## Application for a Non-Material Amendment Following a Grant of Planning Permission

Single storey extension to existing office building to create ancillary gym, with provision of new cycle parking

23/1280/FUL

- 1) Retention of internal structural walls
- 2) Re-location of internal partition walls and doors
- 3) Re-configuration of internal gym space and equipment position

TITLE
GYM - Proposed Plan

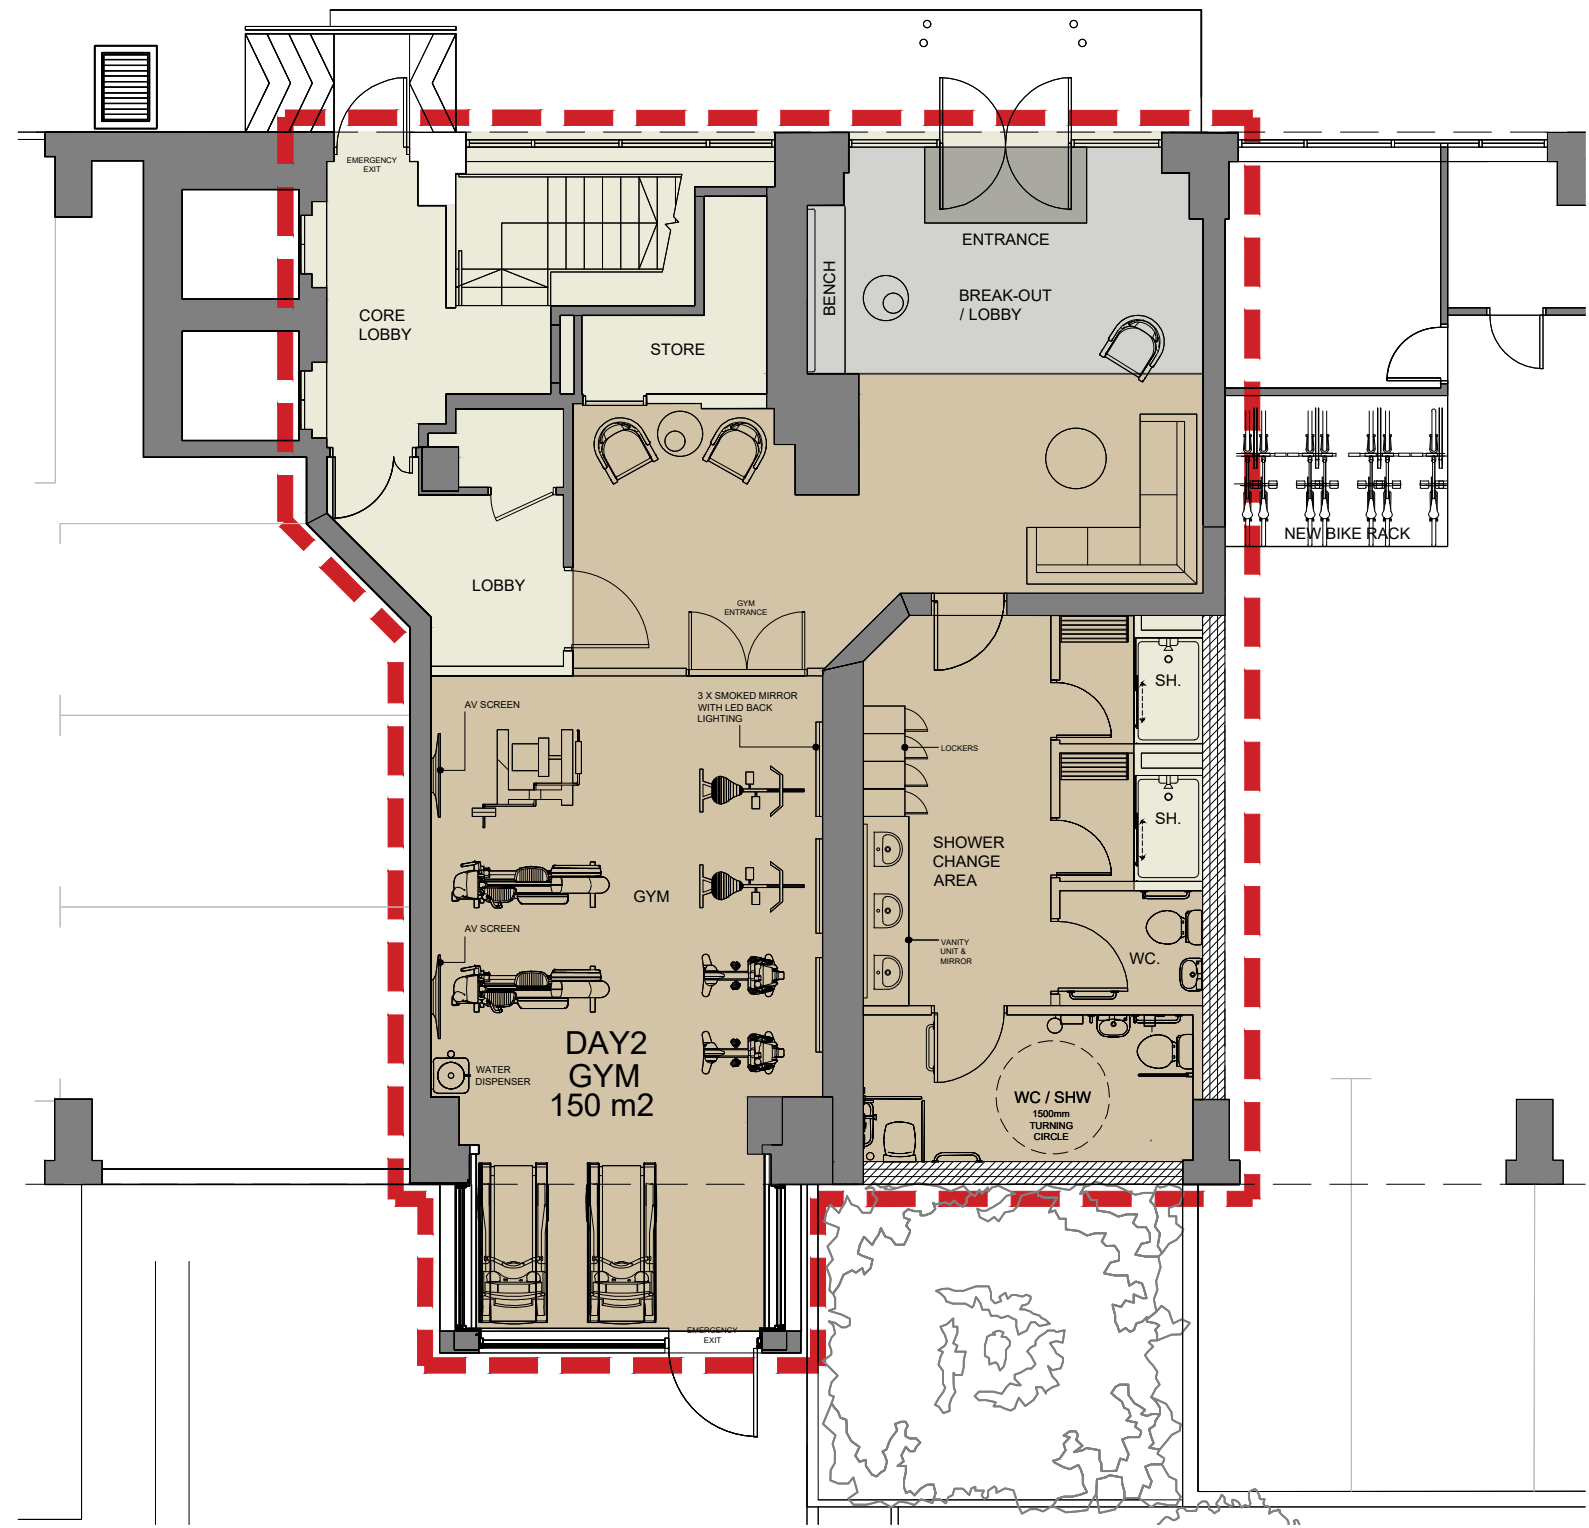
230920\_BW\_PlanApp\_Gym 03 Demolition Plan Rev A (Demolition Plan)  
230920\_BW\_PlanApp\_Gym 04 Proposed Plan Rev A (Proposed Plan)

081A\_BW\_GF\_GYM\_DE Rev B (Demolition Plan)  
081A\_BW\_GF\_GYM\_PR\_Rev B (Proposed Floor Plan)
